Please treat as a rep for A/64/17/DOC

From: Alison Driver [REDACTED]
Sent: 14 May 2017 12:24
To: Anita Gardner
Subject: The Cottrells

Having viewed the new site layout drawing AD962/03 A and read the WSCC consultation I would like to raise the following:

A		Flatbed delivery lorry added		04.05.17	
Rev		Description		Date	
Job Reference			Client		
New House The Cottrells Angmering			AM Homes Ltd		
Drawing Title			Drawing No		
Site Works Plan			AD962/03		
			Rev		
			A		
Date	Scale	Dwg Size	Plot Style	Drawn	Checked
28.02.17	1:100	A3	AD09xscale	TCG	AD

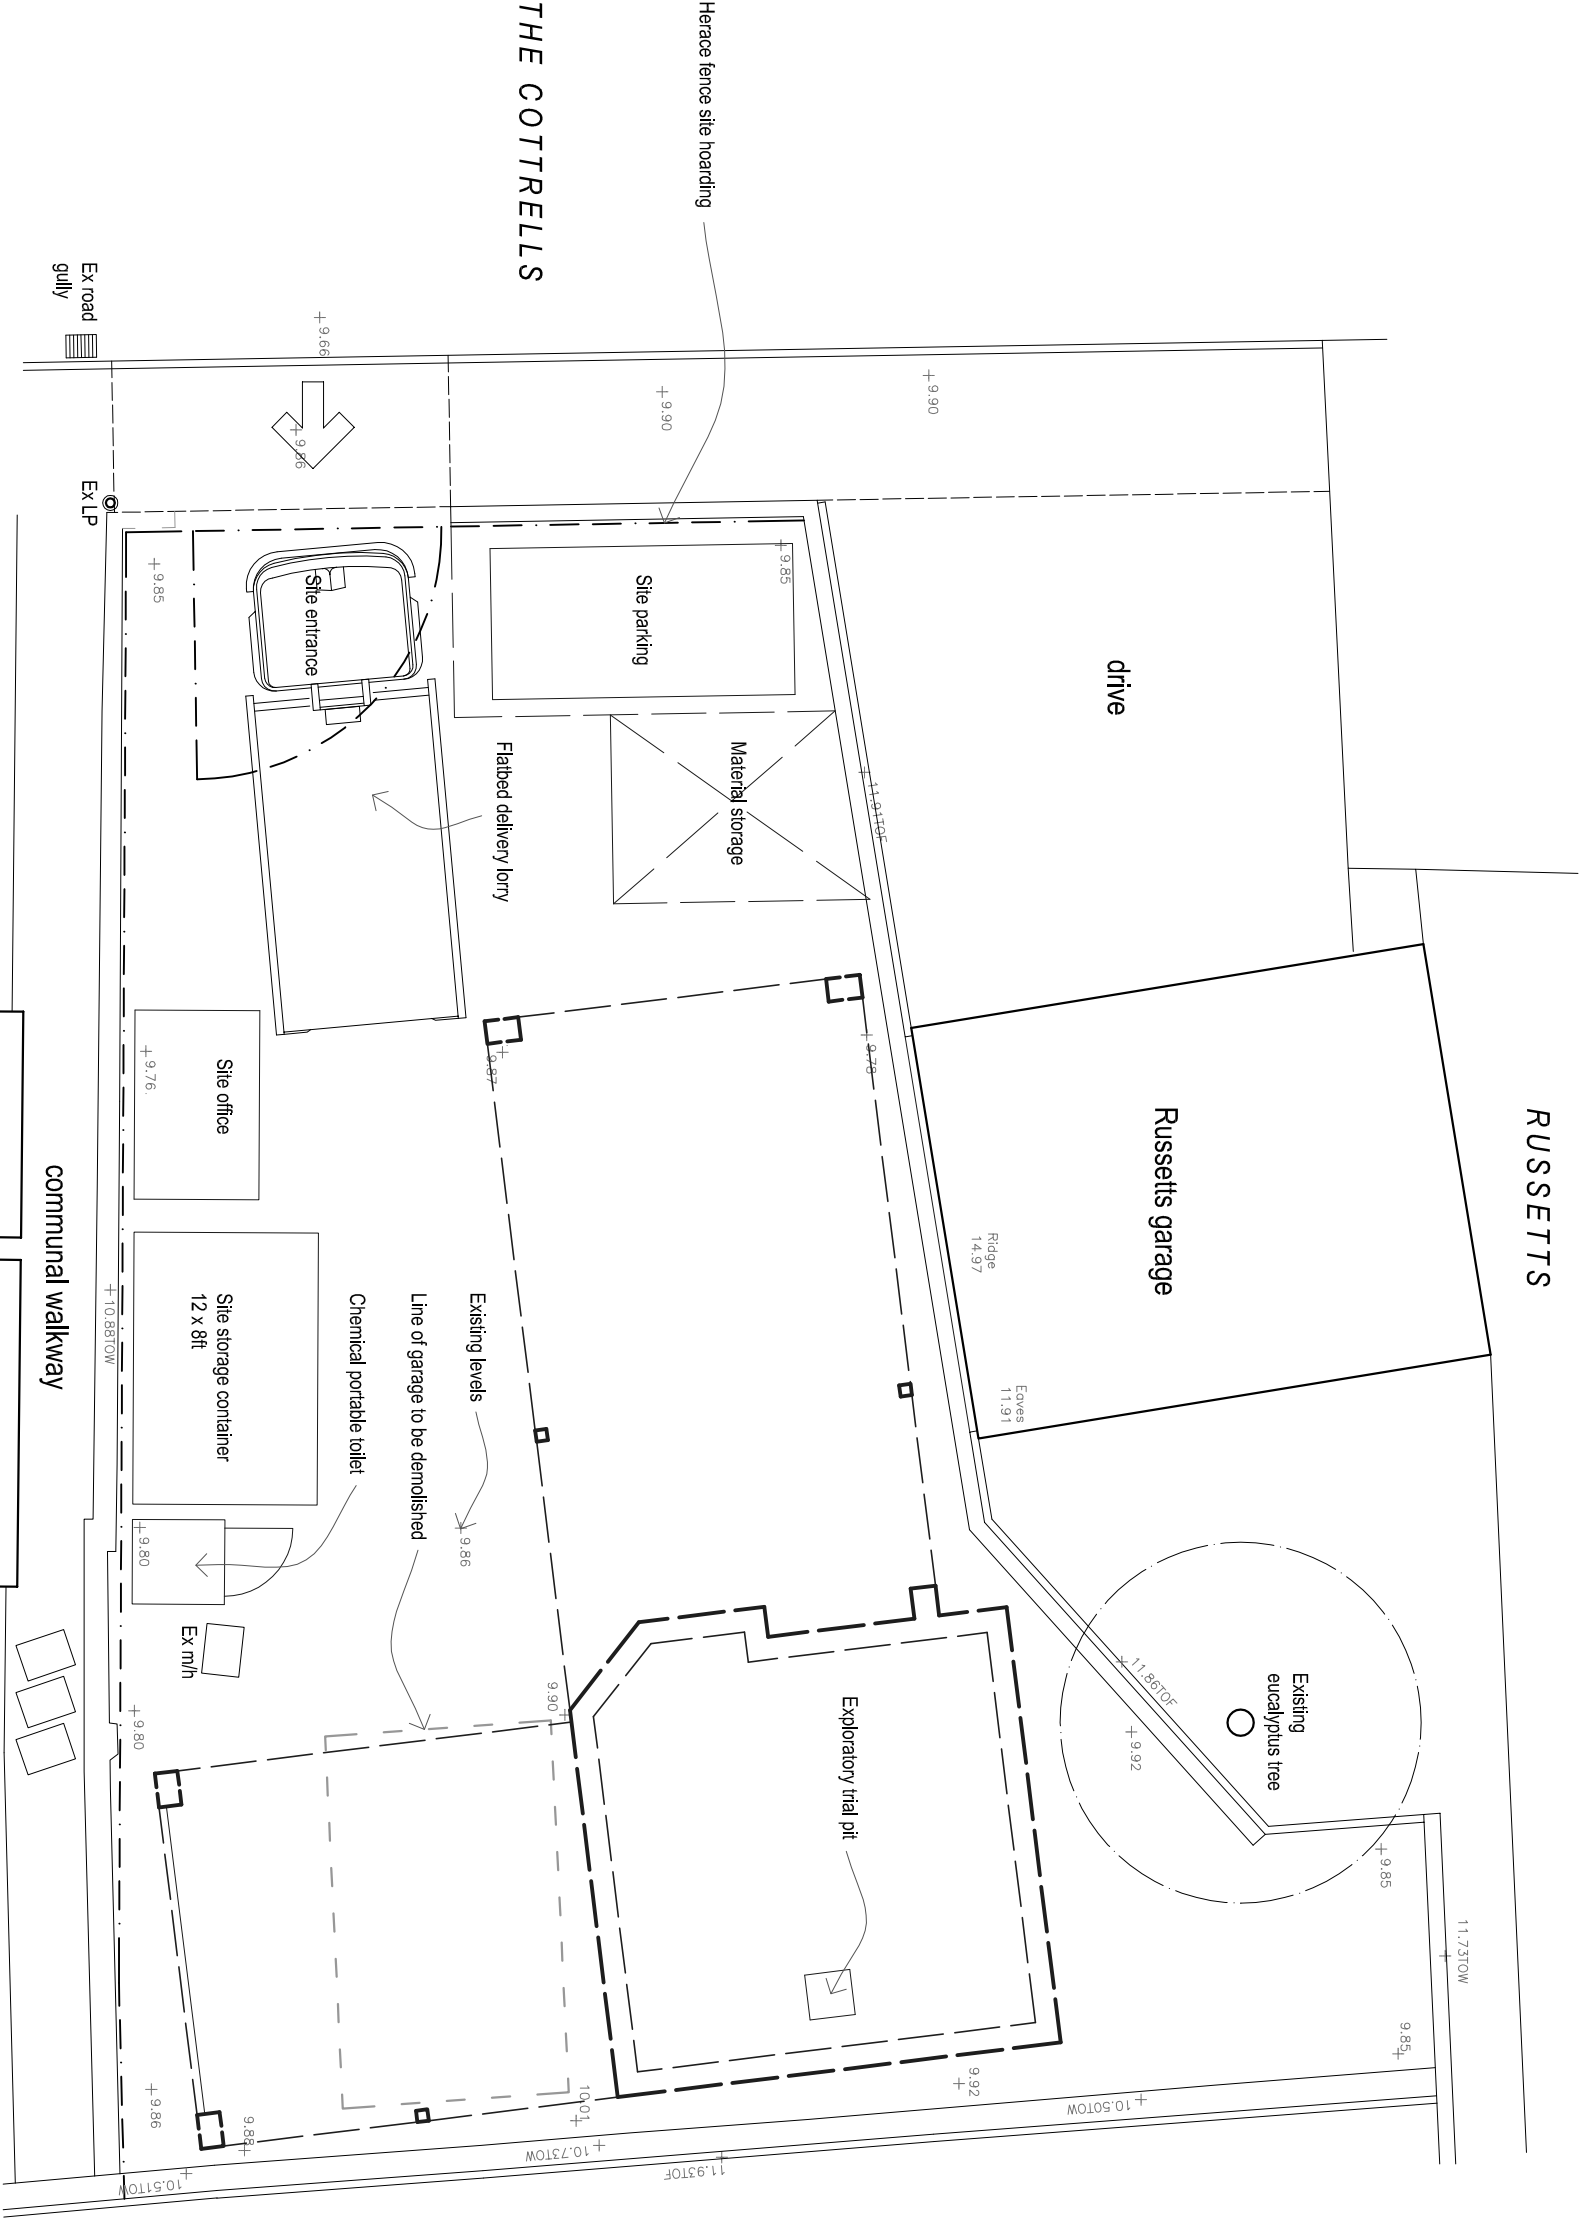
1. WSCC have asked for a banksman to be used for reversing onto and off the site. In addition I ask that banksmen are needed for large vehicles coming into and out of The Cottrells at the junction with the High Street. Access into and out of The Cottrells from the High Street is blind in all directions. There is no pedestrian footpath in The Cottrells road and it is so narrow that any vehicle above 3 tonnes has to fold in its wing mirrors. There is no pavement on one side of the High Street at the junction with The Cottrells. Pedestrians are very vulnerable at this point, and there is no alternative to walking in the road. It is a busy pedestrian route into the centre of the village and to the schools. It is frequently used by parents with small children, school children and elderly residents. There is a very real risk that large trucks could turn into The Cottrells from the High Street and pedestrians be directly in their path. The road has an incline which means vehicles making the turn are also accelerating to make the gradient. On leaving large trucks may not have their wing mirrors out and hence blind to their rear, at the junction they may go to pull out and need to reverse suddenly to avoid a collision with a vehicle in the High Street. If vehicles or pedestrians are in the road behind they would have no warning and an accident could easily occur. Without seeing the site on the ground it is very hard to appreciate just how narrow the roads are and how tight the turns are. The construction site is a short walk from the High Street and easily accessed by the banksmen operating from the site.

2. WSCC have also noted that some deliveries may need to be undertaken from the roadside. If the vehicles delivering to the site do not fit on the site they will block the road completely, if this is

unavoidable the residents need to be made aware of the timings in advance so they can make the necessary arrangements to avoid being blocked into and out of the road. Signs need to be in place to avoid vehicles turning off the High Street into The Cottrells. If no warnings are given and vehicles turn from the High Street into The Cottrells it could be impossible for them to safely reverse back onto the High Street (because it is blind) and hence complete grid lock occur.
